Application No: AB/14/21/HH
Site Address: Riverside House 2 Fitzalan Road Arundel BN18 9JS
Description of works: Reinstatement of timber jetty using existing 3 piles.

Thank you for your internet representation made on 23rd March 2021 which has been recorded as an objection with the comments as follows:

JETTY
PROPOSED SITE LAYOUT

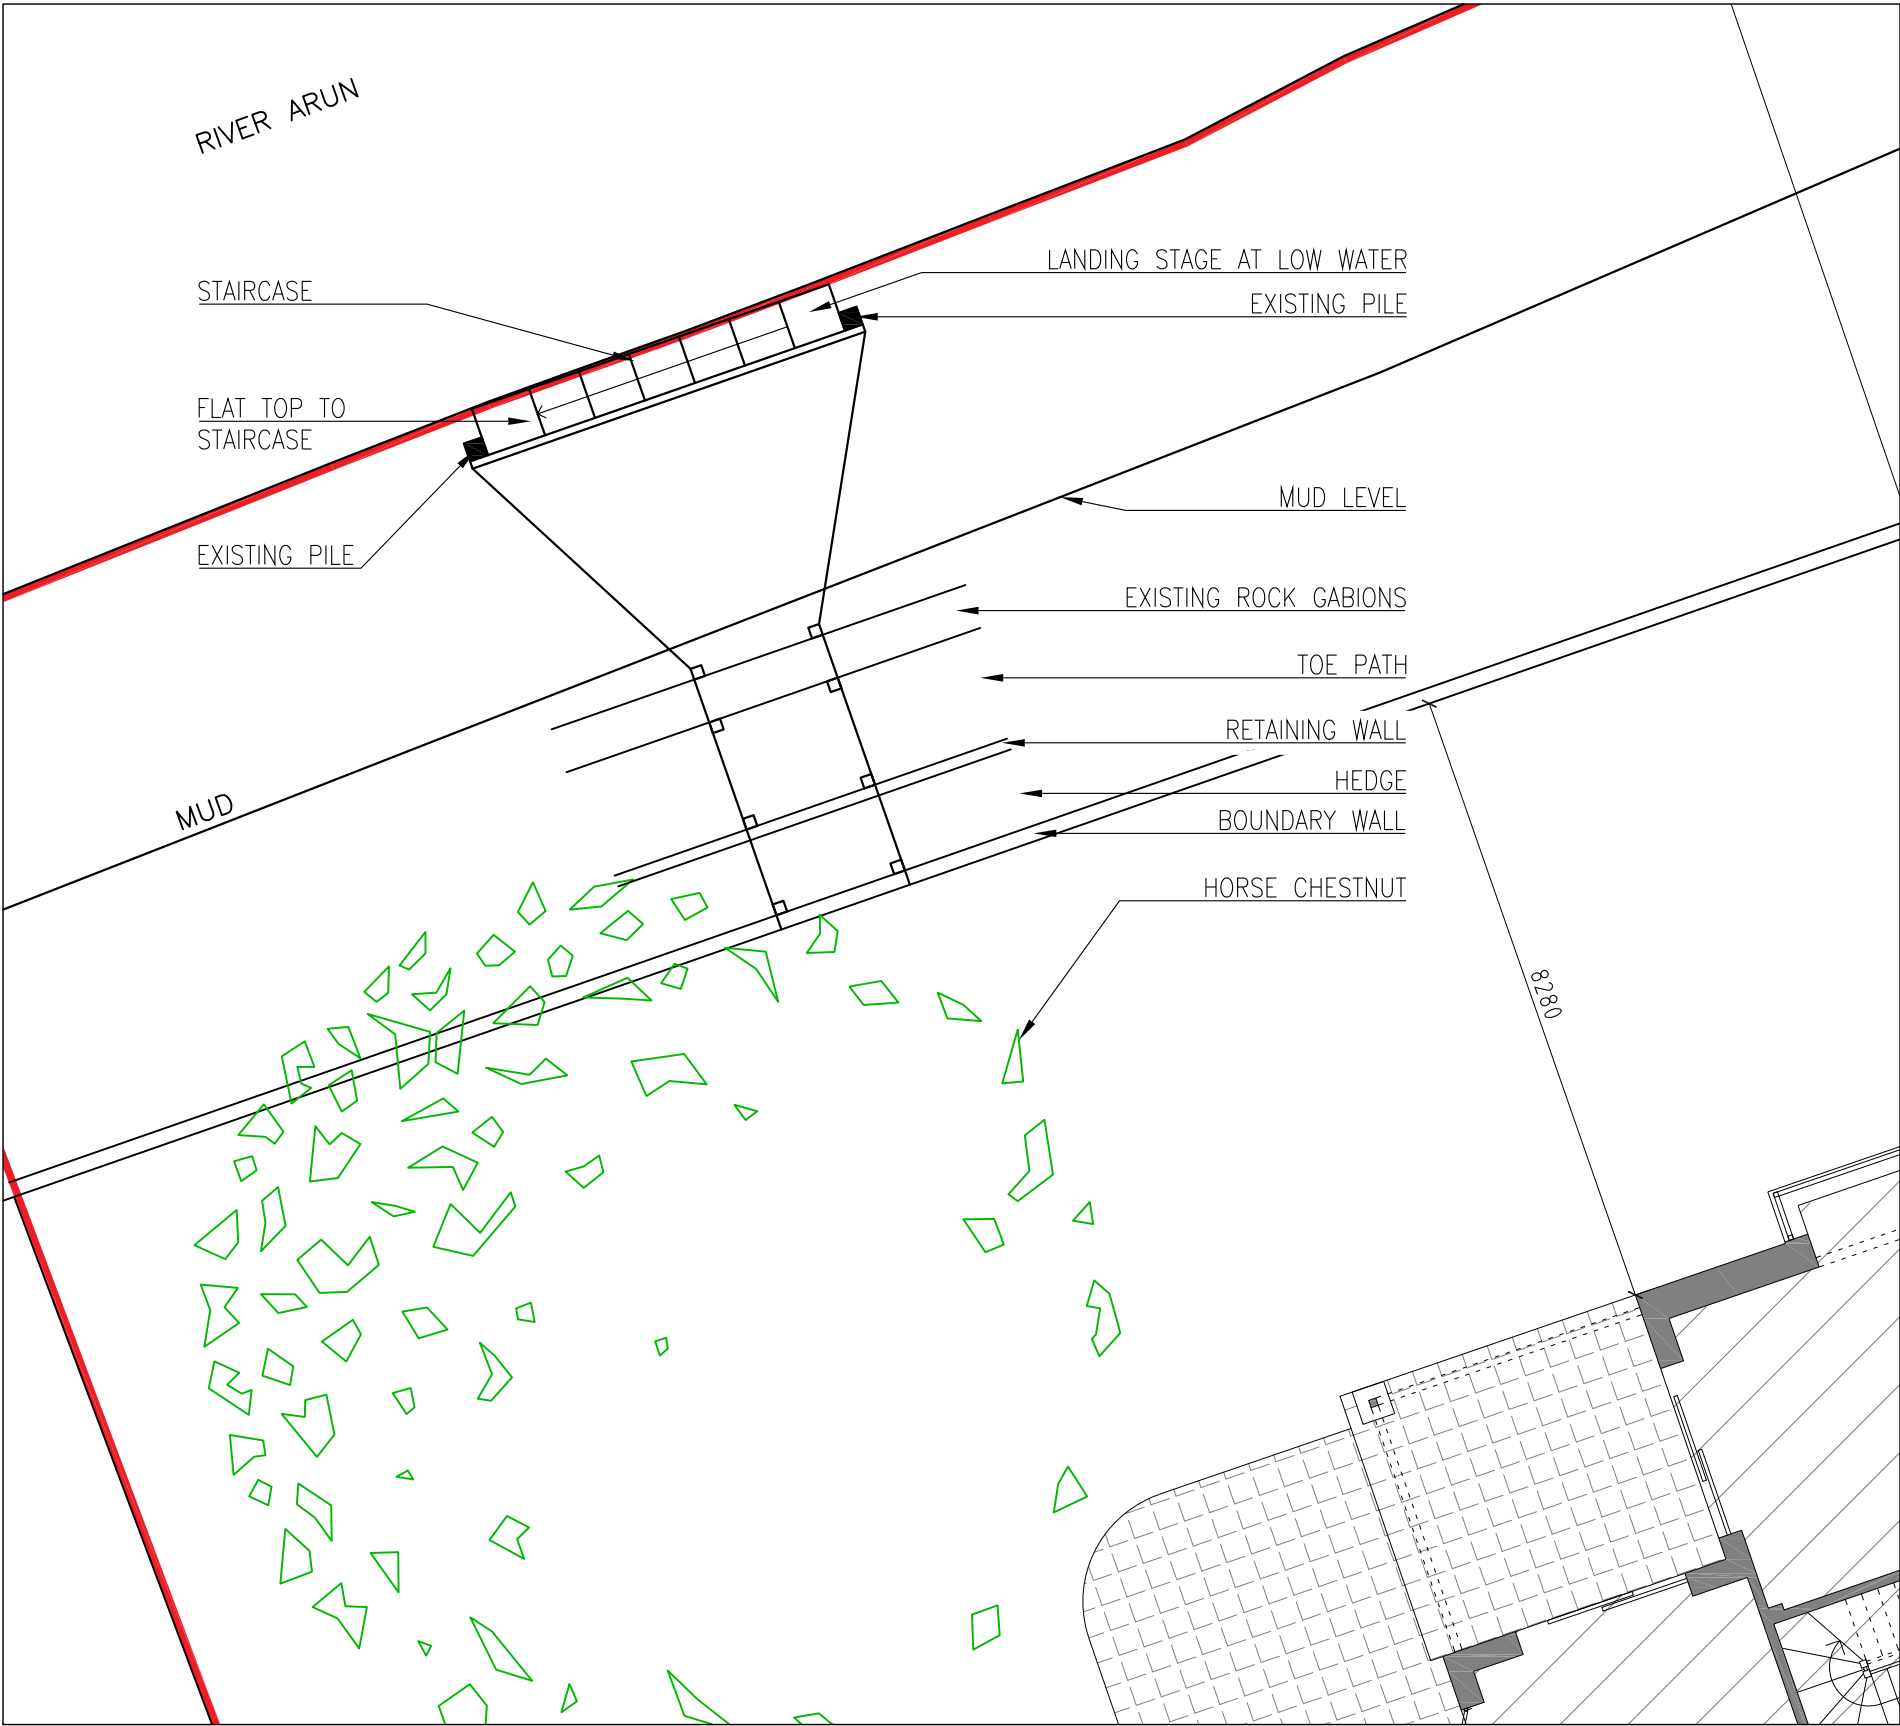
The Committee objected to the steps being built over the wall as this would be intrusive to neighbours and give a loss of privacy.

JETTY
PROPOSED EAST AND WEST ELEVATIONS

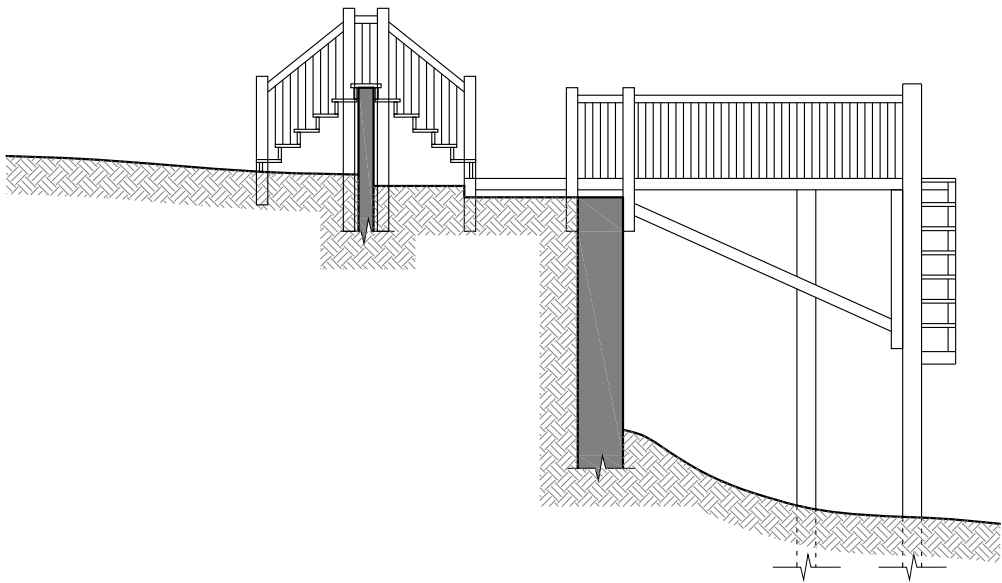
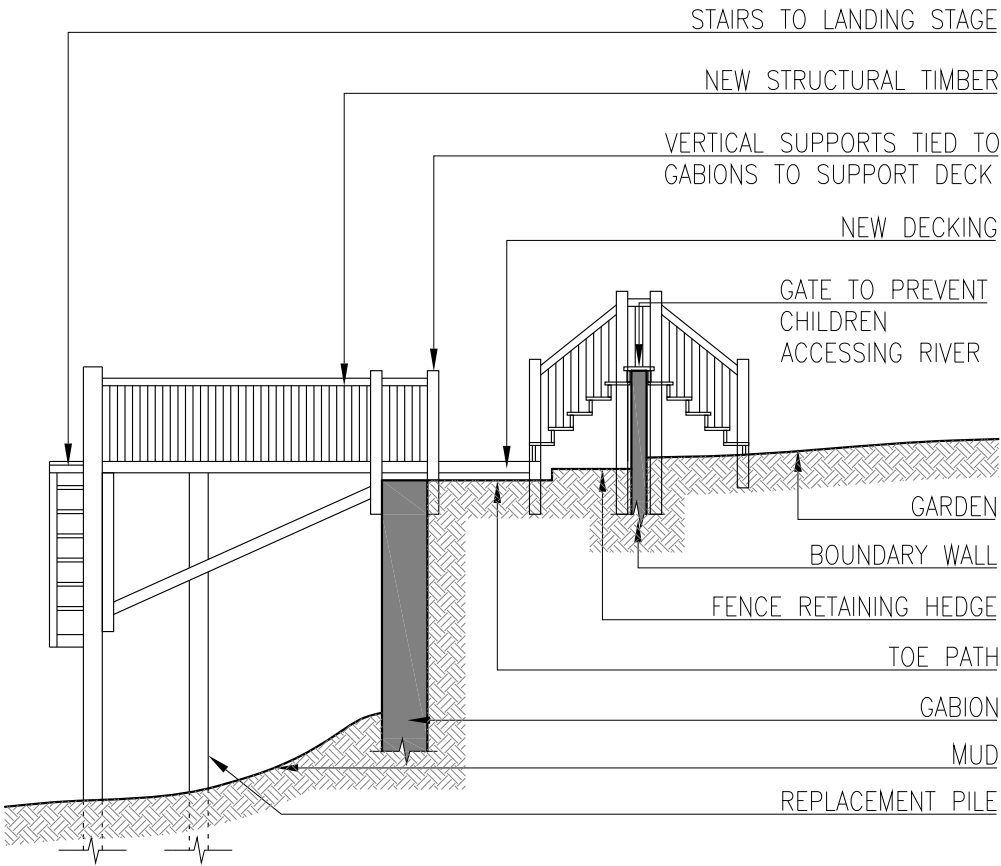
The Committee have no objection to the jetty being reinstated.
